Planning Comment Responses
Project Name: WaFd Bank Mercer Island
7633 SE 27th Street
Permit Number: DSR23-015/TCC23-013

Please see below for our responses to the Notice of Incomplete Application comments received on 12/14/2023 regarding the submission of drawings for the proposed WAFD Bank Mercer Island branch.

ENL. SITE PLAN & PROPOSED FLOOR PLAN **N** SCALE 1/8" = 1'-0" **2**

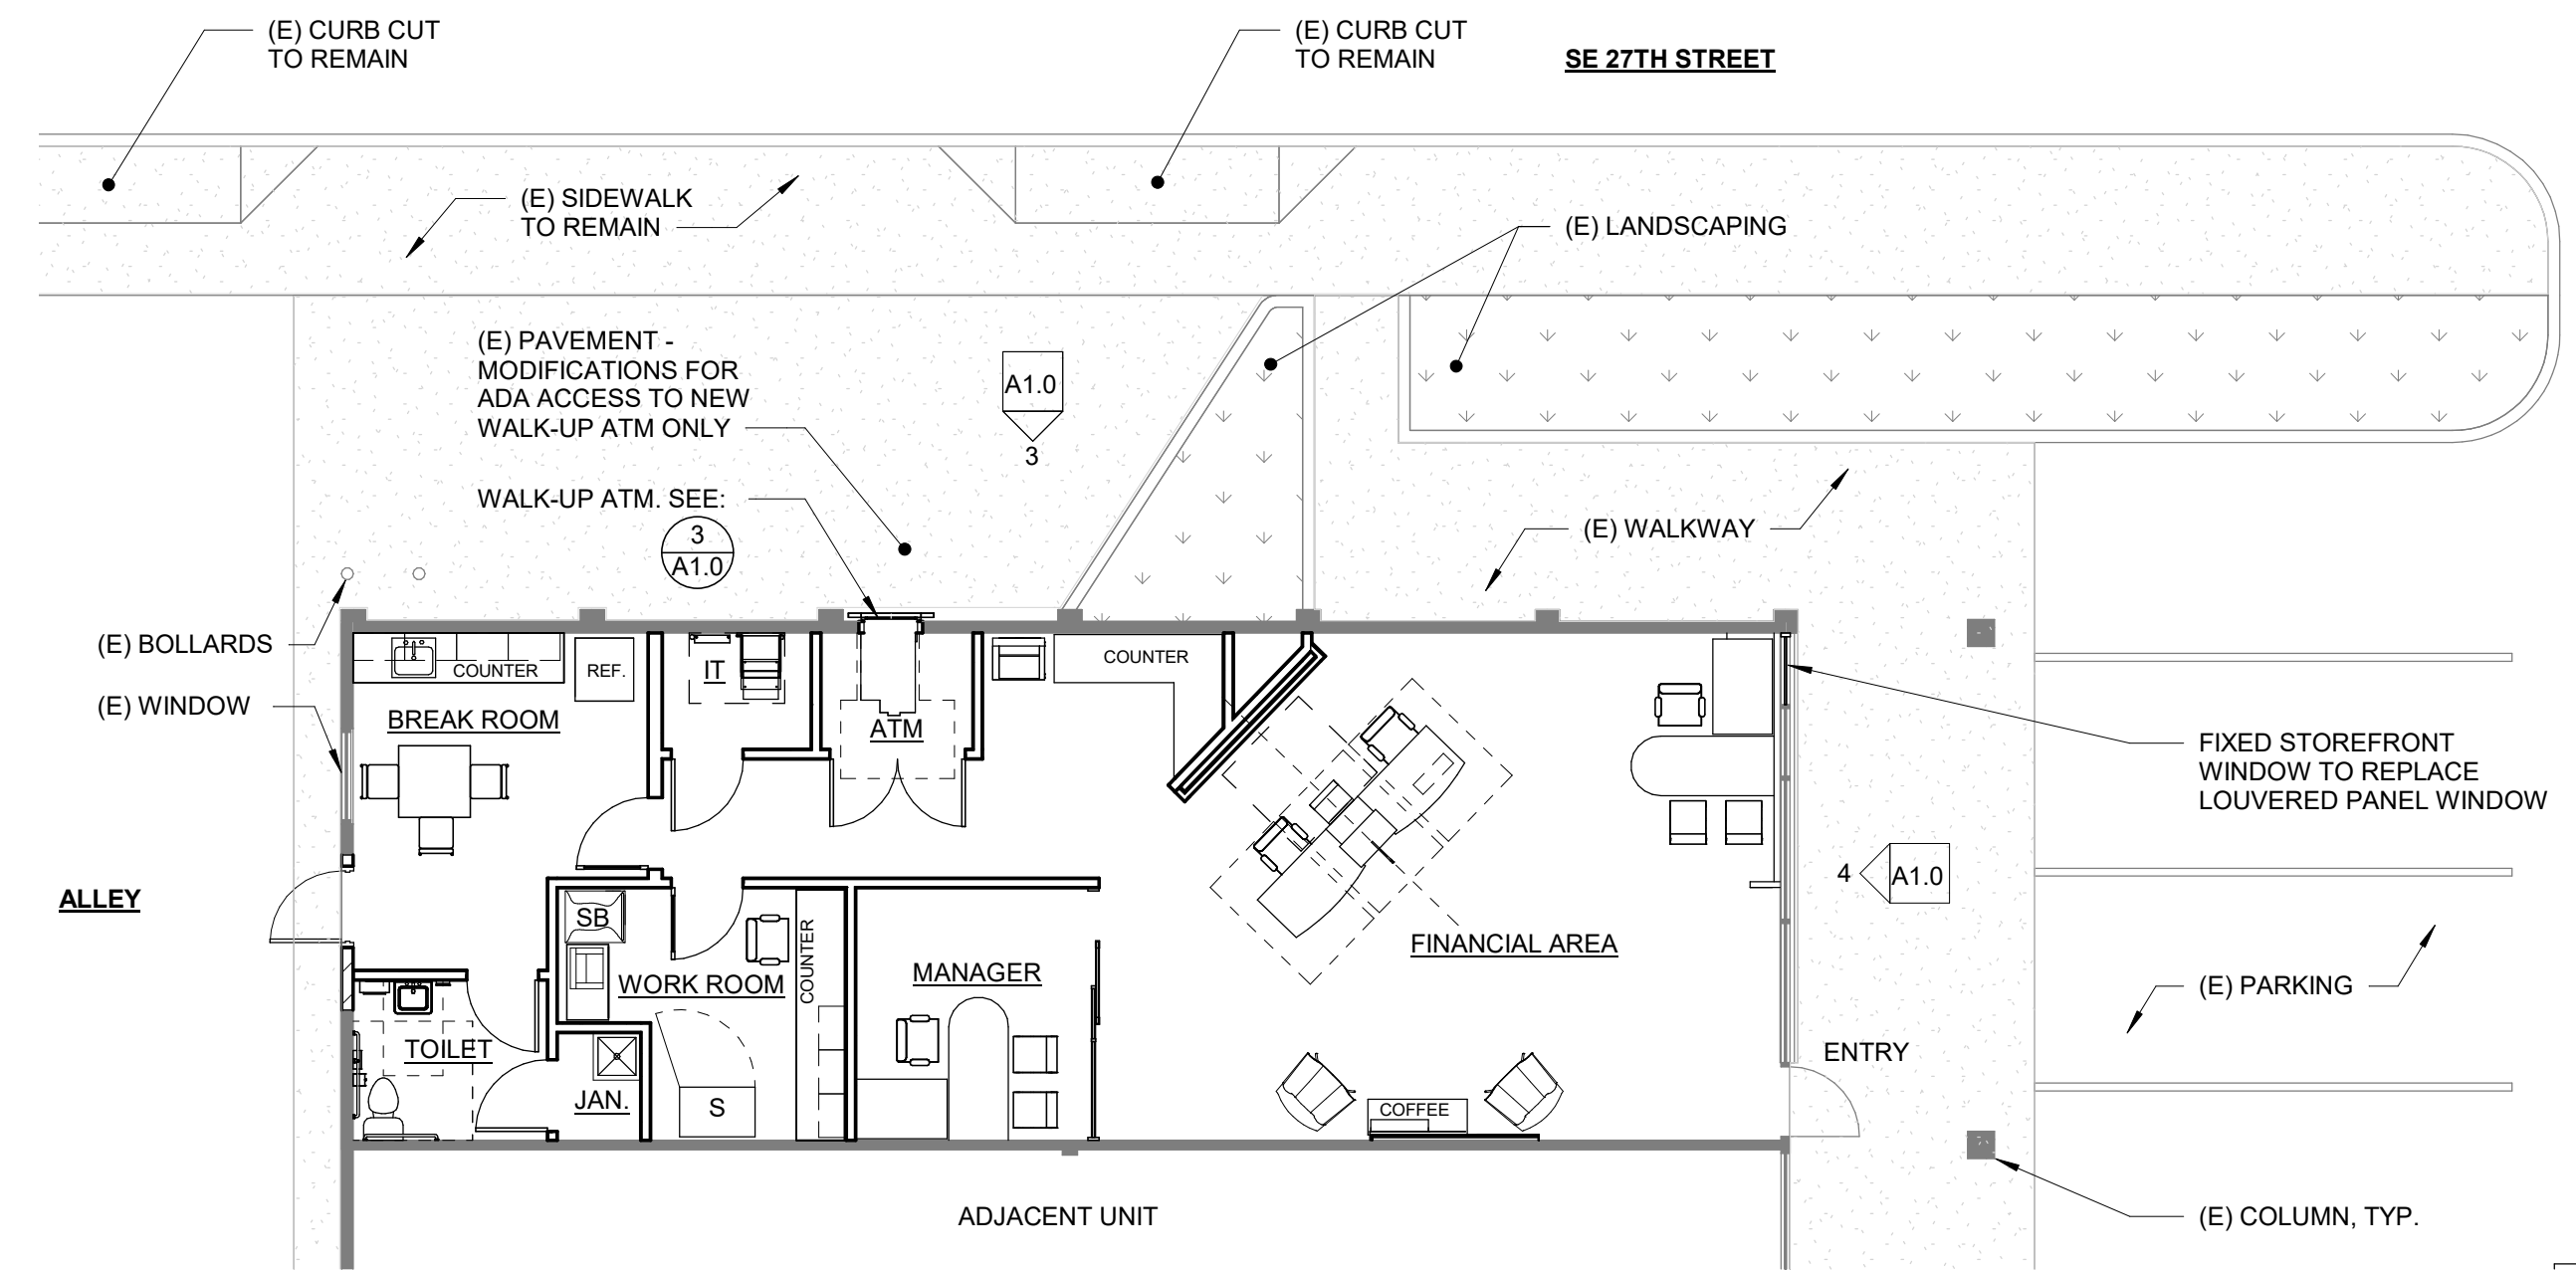
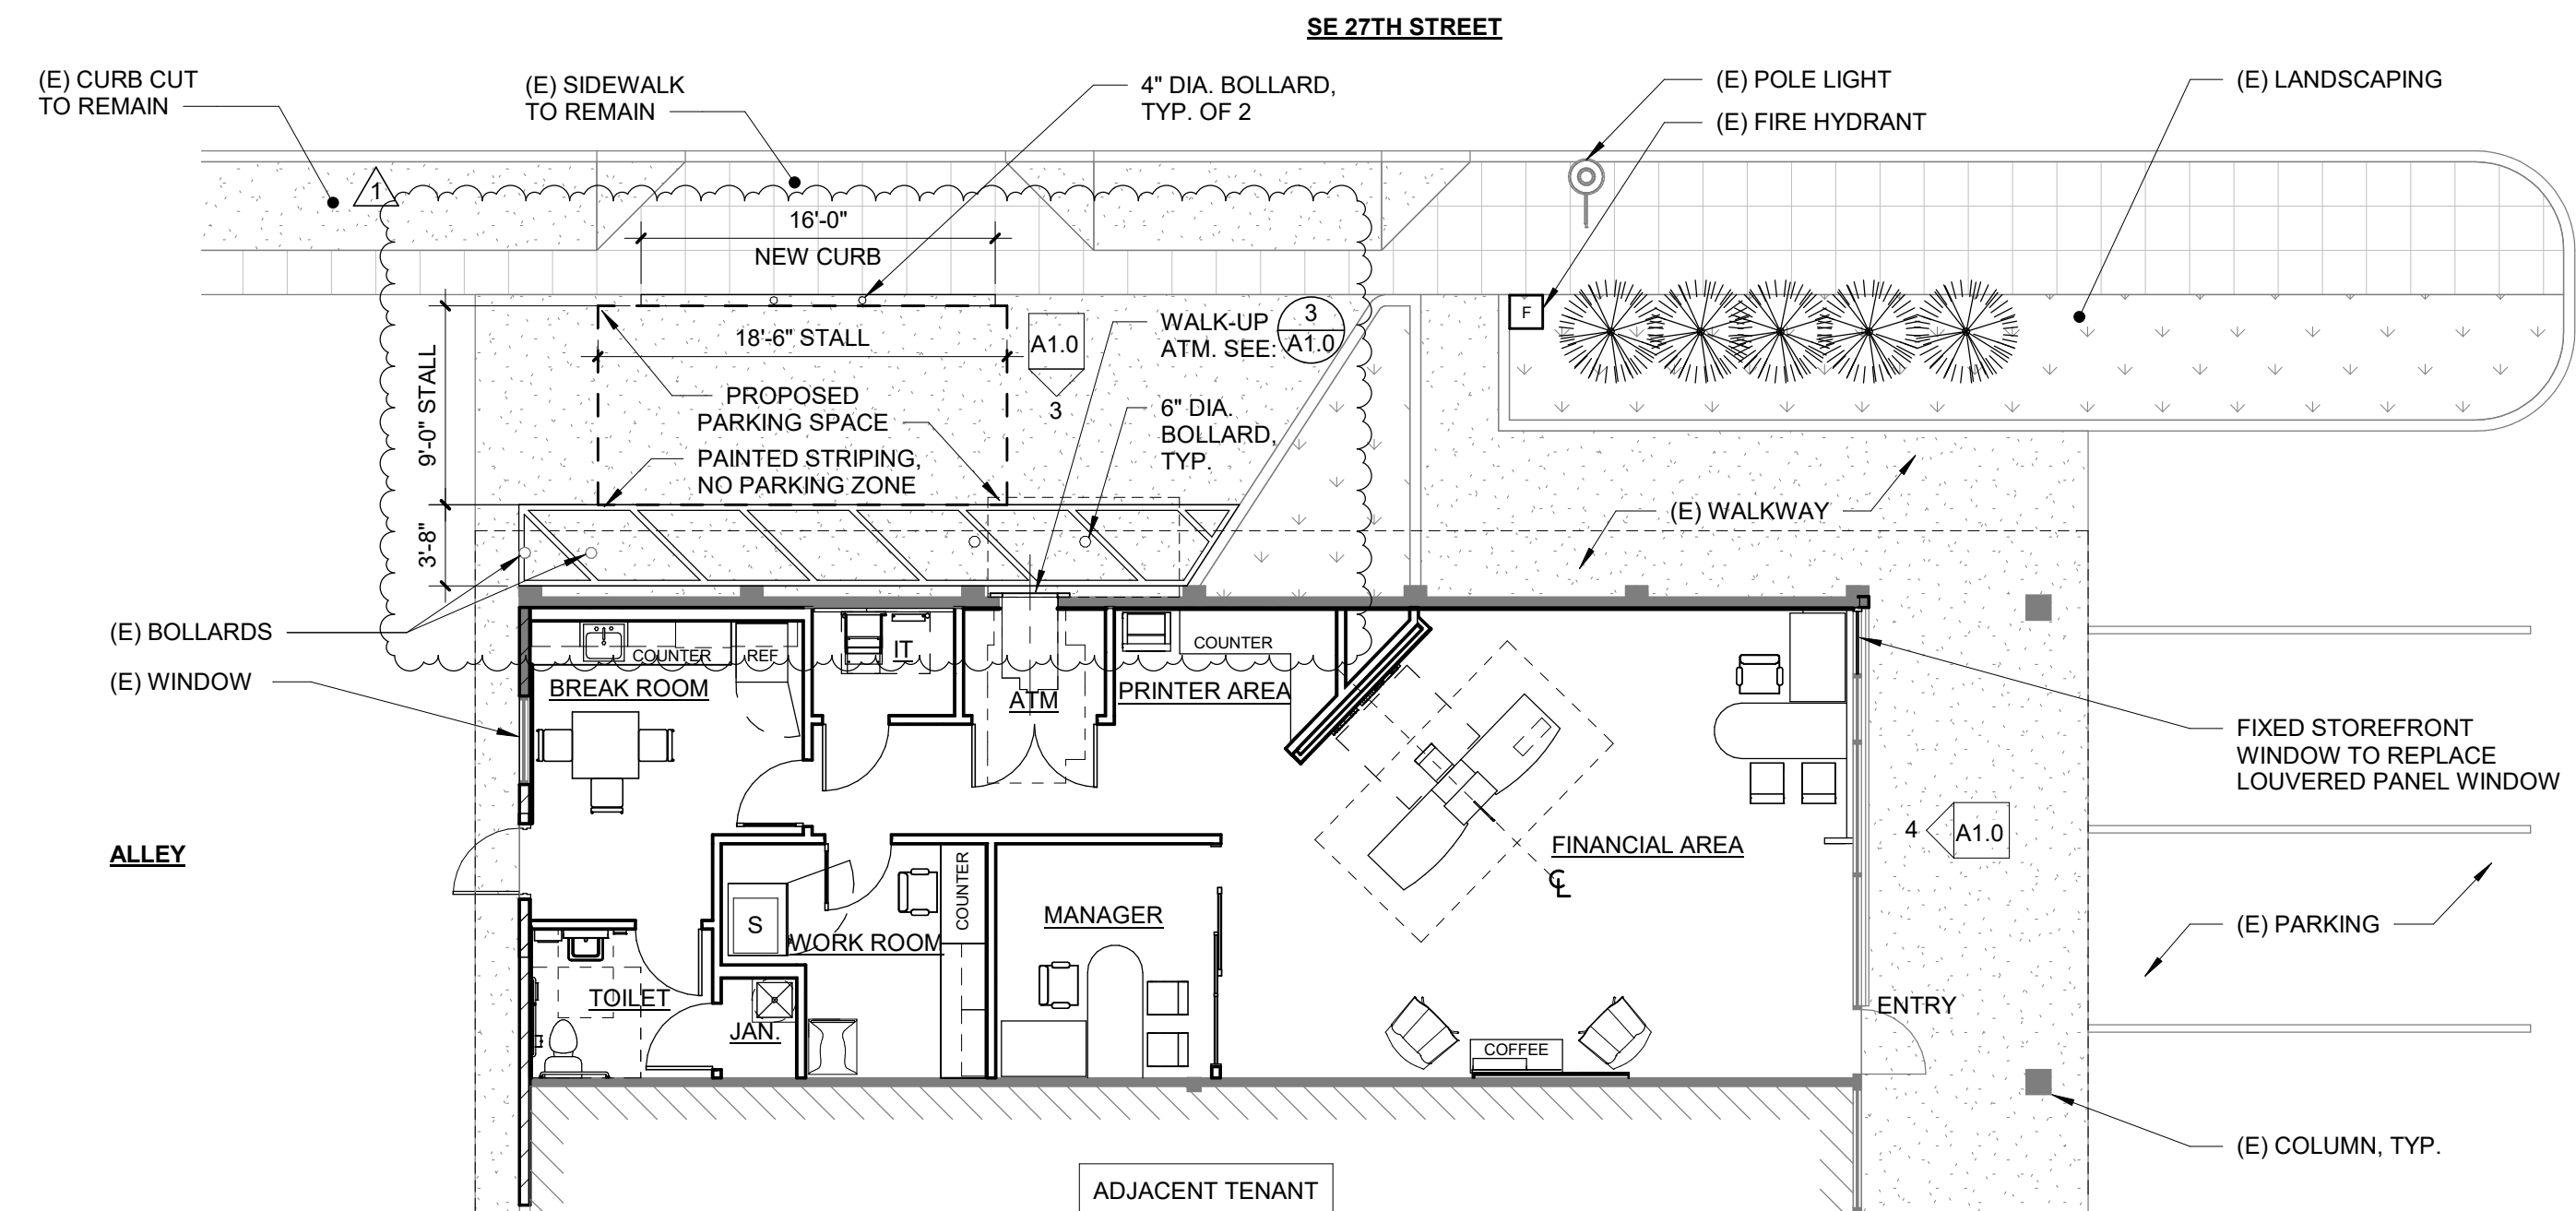
1. A1.0 SITE PLAN AND ELEVATIONS – The enlarged site plan and proposed floor plan (detail 2/-) was updated to show a proposed parking space at the former dry cleaner drop-off area of SE 27th Street.
